**Tyne Hill Farm  
Sibford Gower  
Banbury  
Oxfordshire OX15 5AD**

14th May 2018

**Your Reference: 18/00640/F Application for new private driveway to Tyne Hill Barn.**

Comments in Support of Application

Drawing Title  
 Site Section and Proposed Site Plan

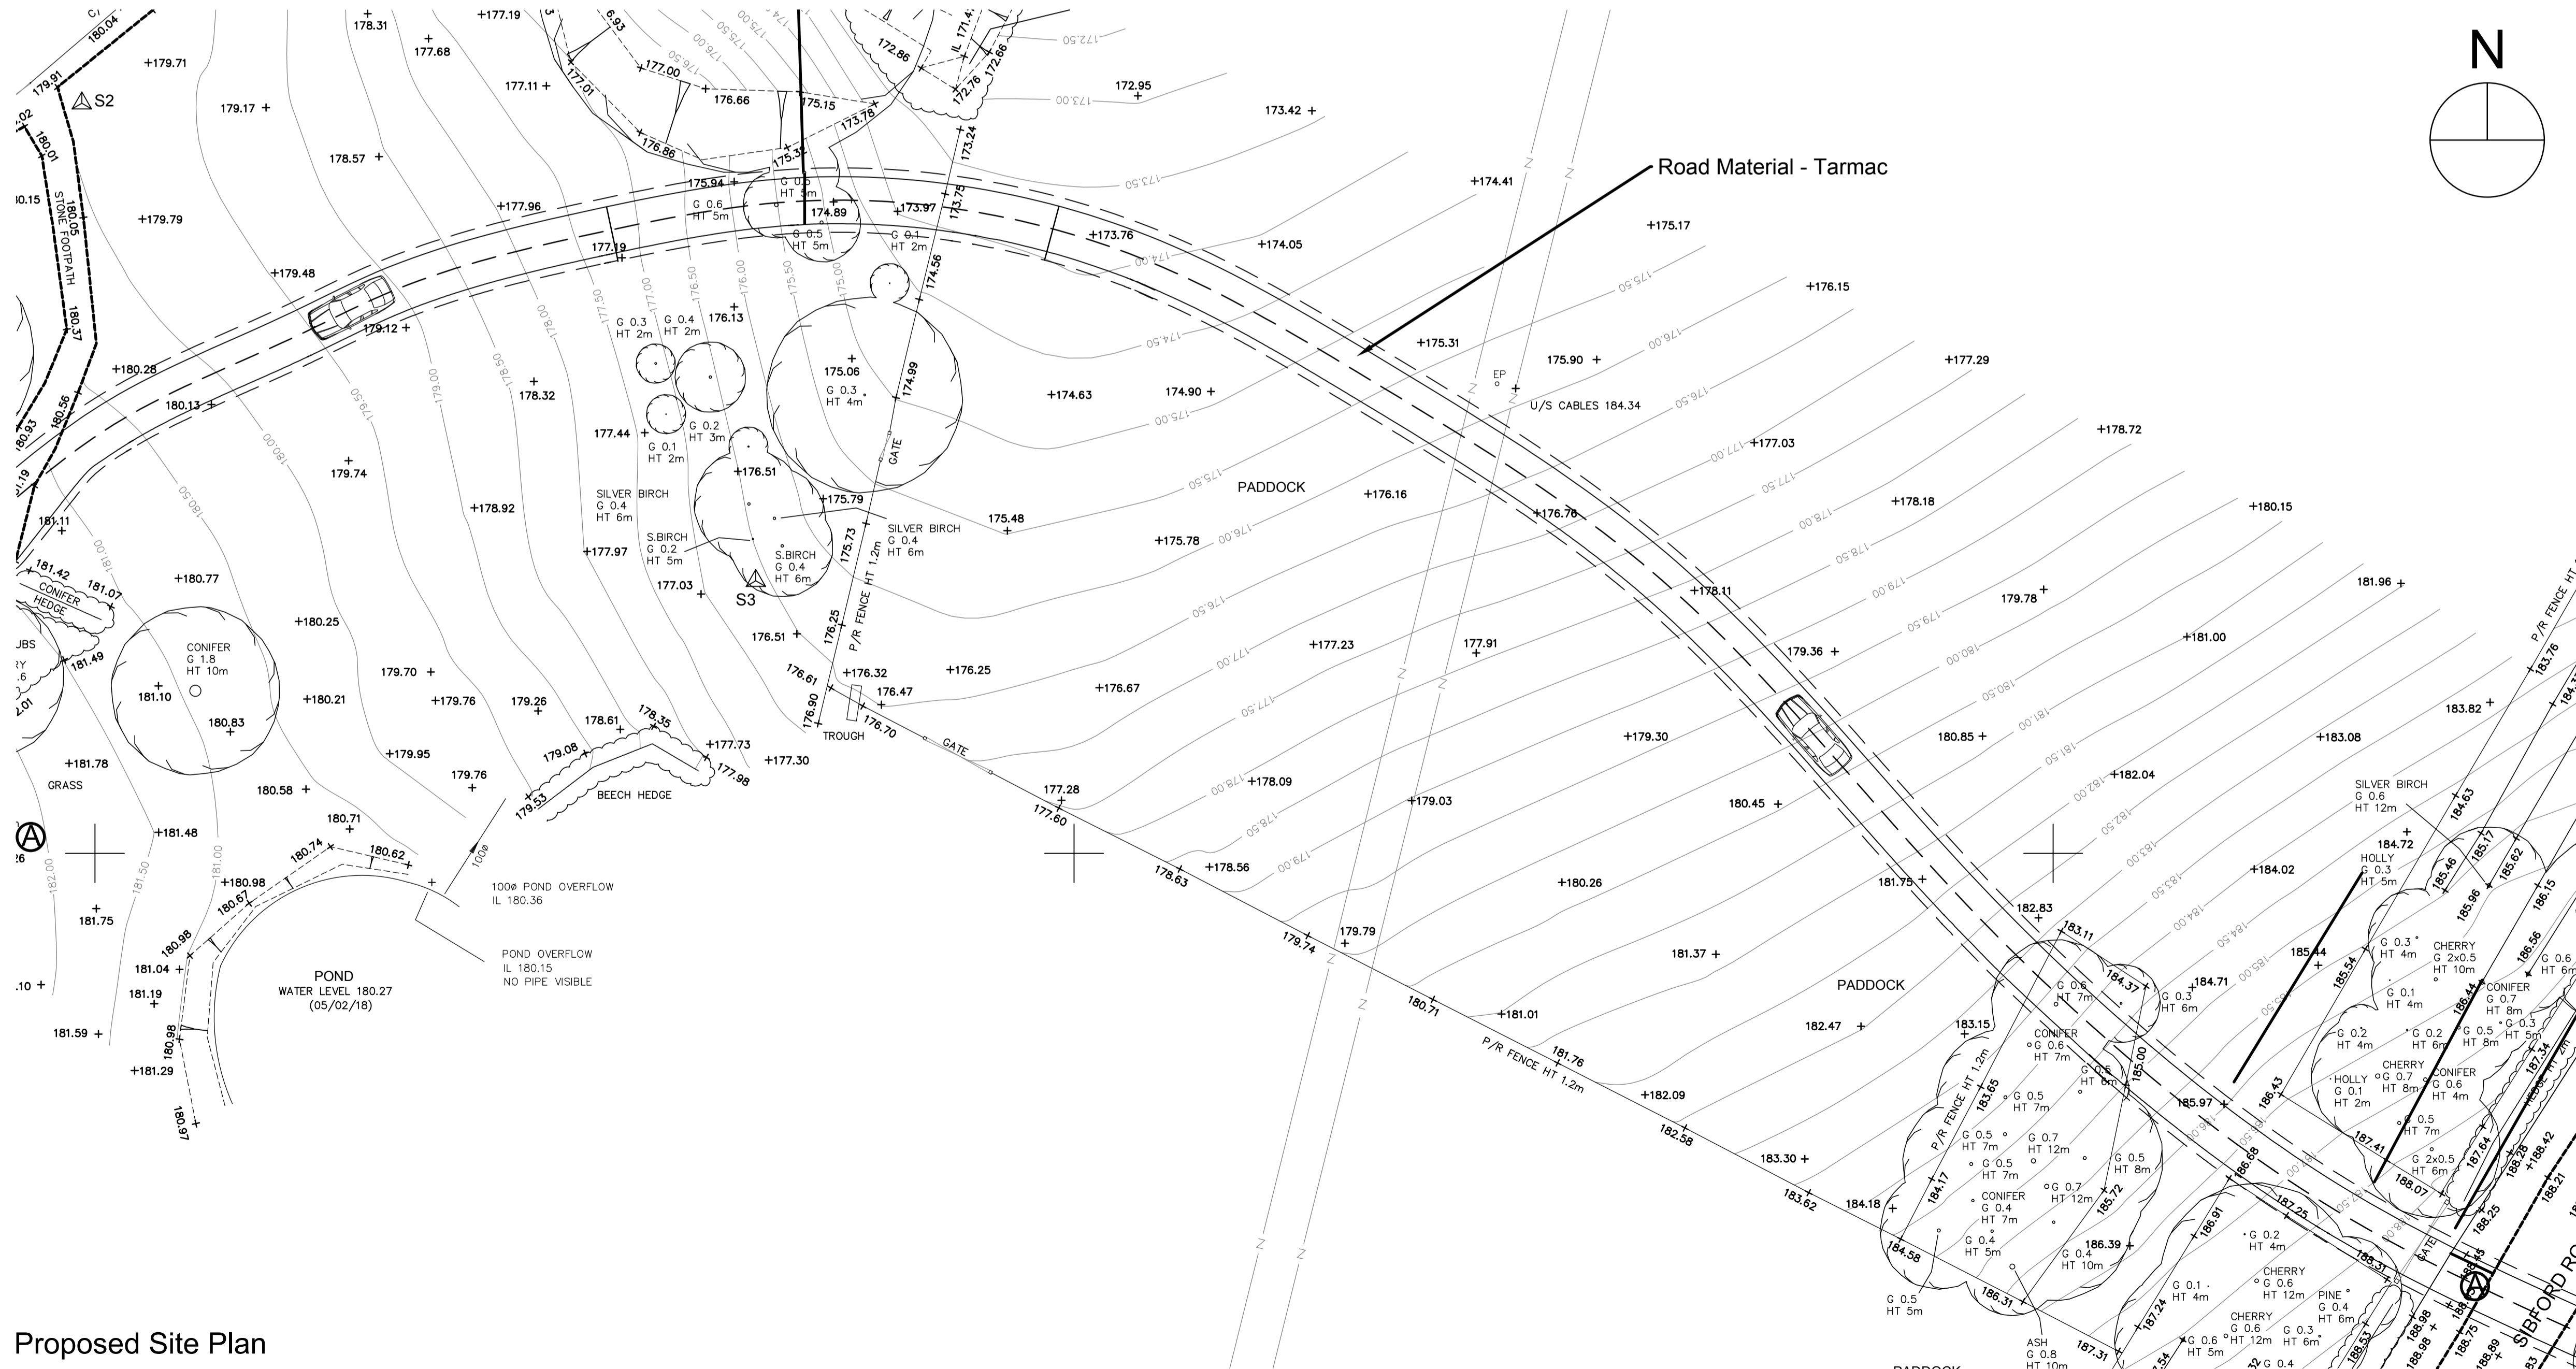
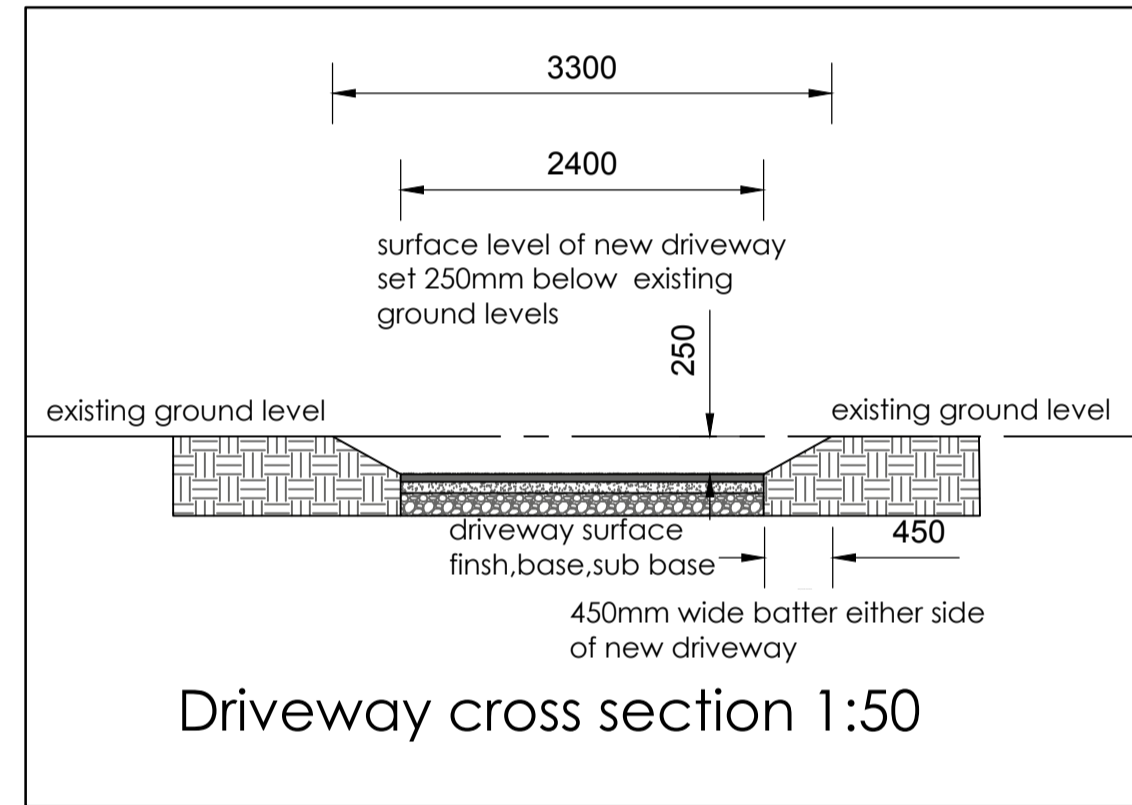
It is noted that the Traffic Survey was carried out on 5th December 2017 being at a time of year when traffic is at its minimum. During the Spring and Summer months the Sibford Road carries a considerable amount of fast moving and large farm machinery. The submitted plans do not seem to accurately portray the steep gradient of the proposed new drive up to the Sibford Road.
